CASE NO: PWDN-154

January 3, 2001

**Re: Schwartzman Industrial Center Drainage Master Plan
Engineer's Stamp dated 9-29-00, (P14/D4) PWDN 154**

**SCHWARTZMAN--RIO BRAVO**  
**DRAINAGE MASTER PLAN**

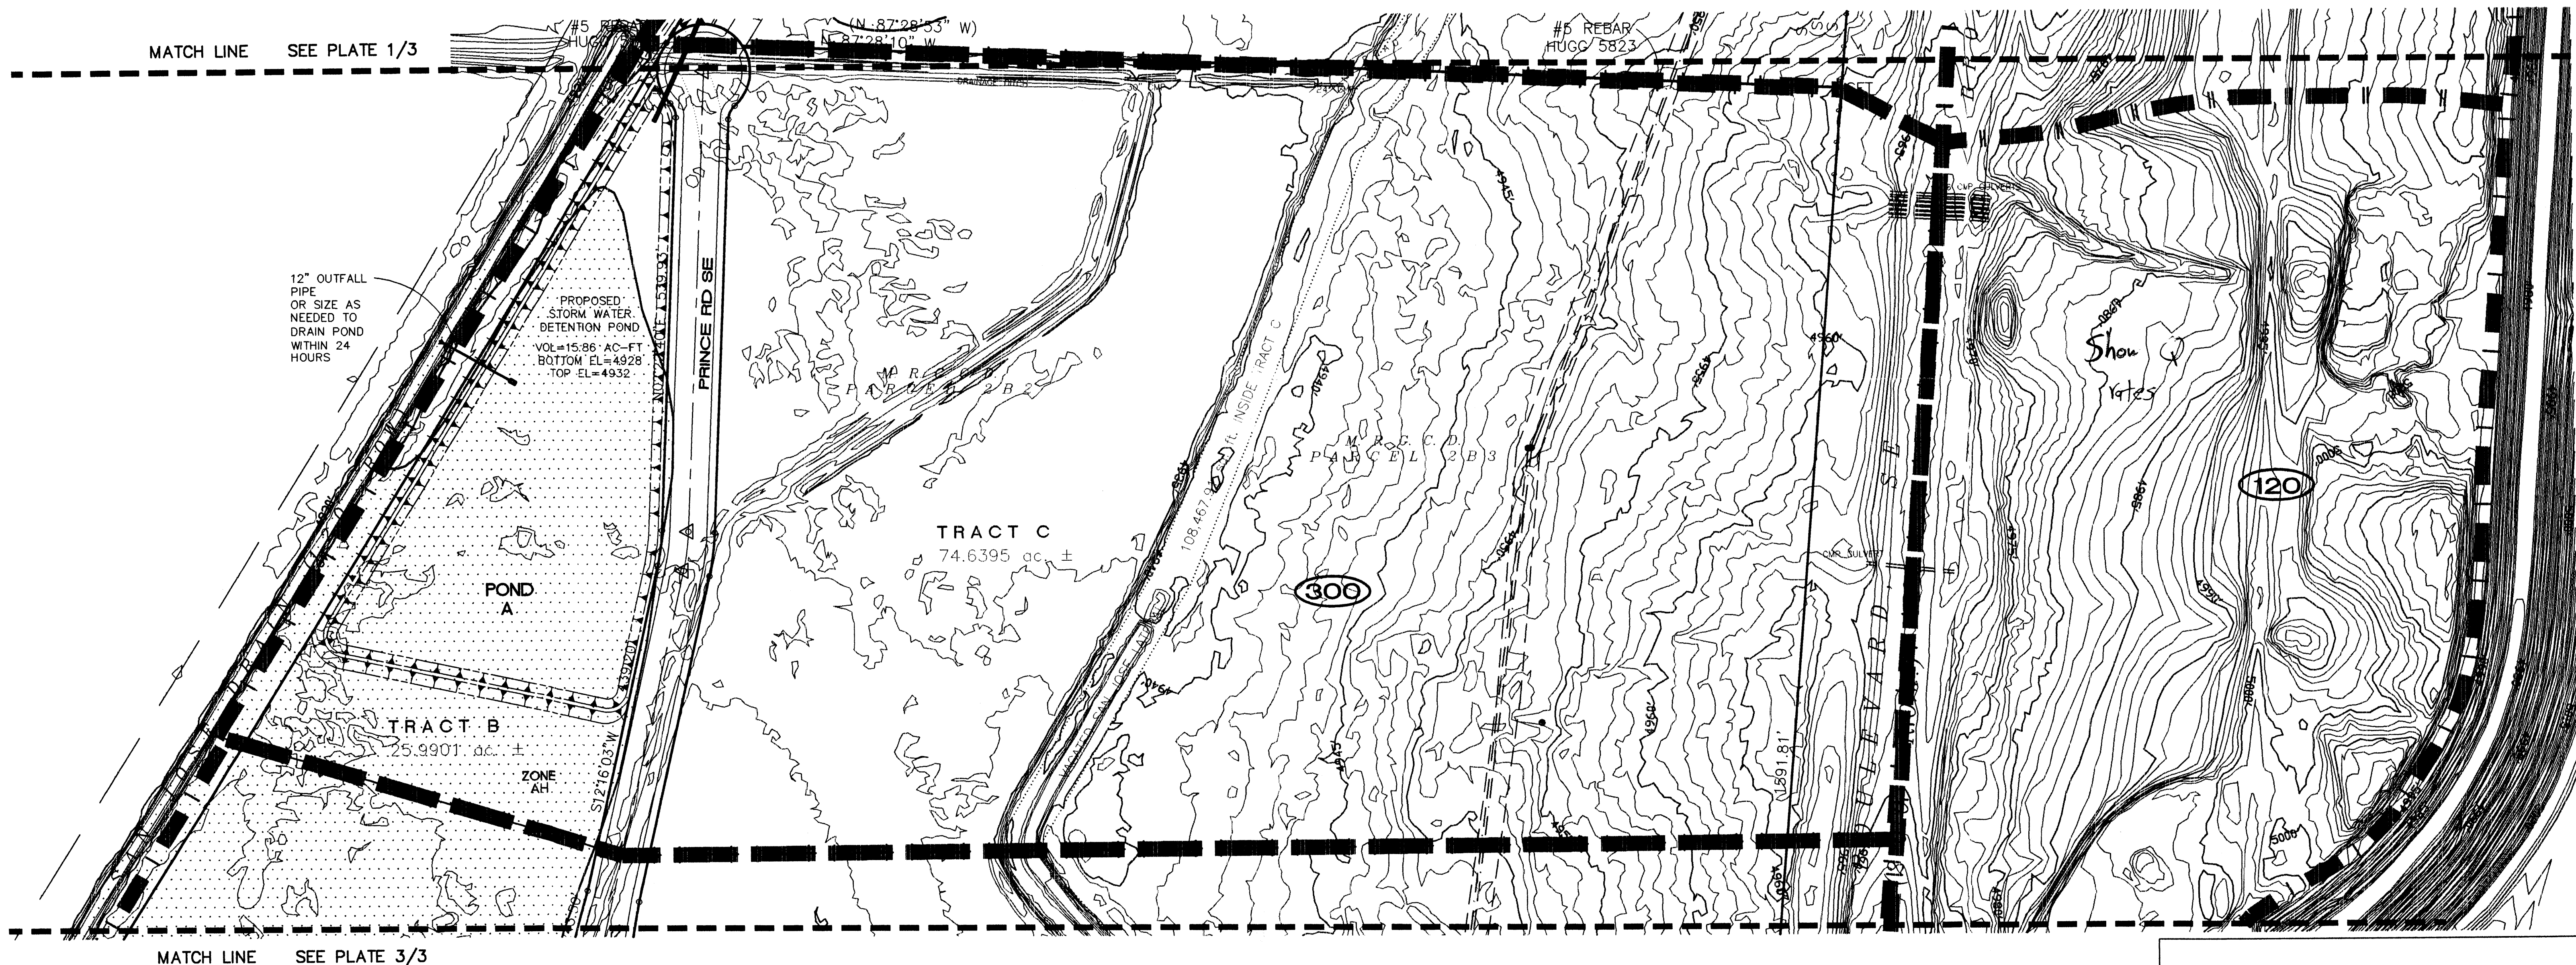
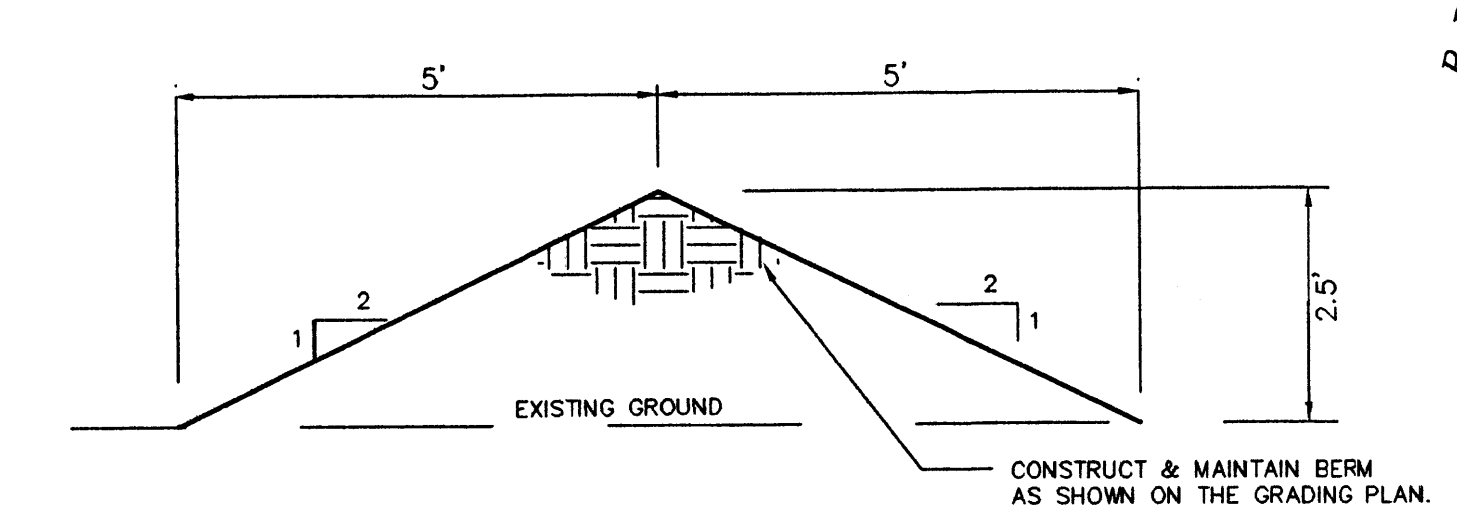
- The offsite runoff and volumes from basins 100, 110 and 120 should be considered as developed and be managed in your plan. Please describe how this will occur (i.e. will they be ponded or allowed free discharge, and will this conveyance be by sheet flow or a controlled access point). You show existing culverts but will need to provide calculations to determine what capacity they contain.

- Please provide information on who will be responsible for the CLOMR/LOMR required to develop this property. The onus should be on the present owner.
- Please provide detailed information on your exhibits (i.e. flow rates, conveyance points, which pond(s) is public, etc). Descriptions of the ponds in the report should match the exhibits. Also, please show the existing shopping center impacted by basin 320.

- By limiting all basins to 4.41 cfs/acre, you are requiring the designer of each site to possibly pond their runoff. Since you have regional public ponding planned, it would be prudent to design for fully developed runoff.
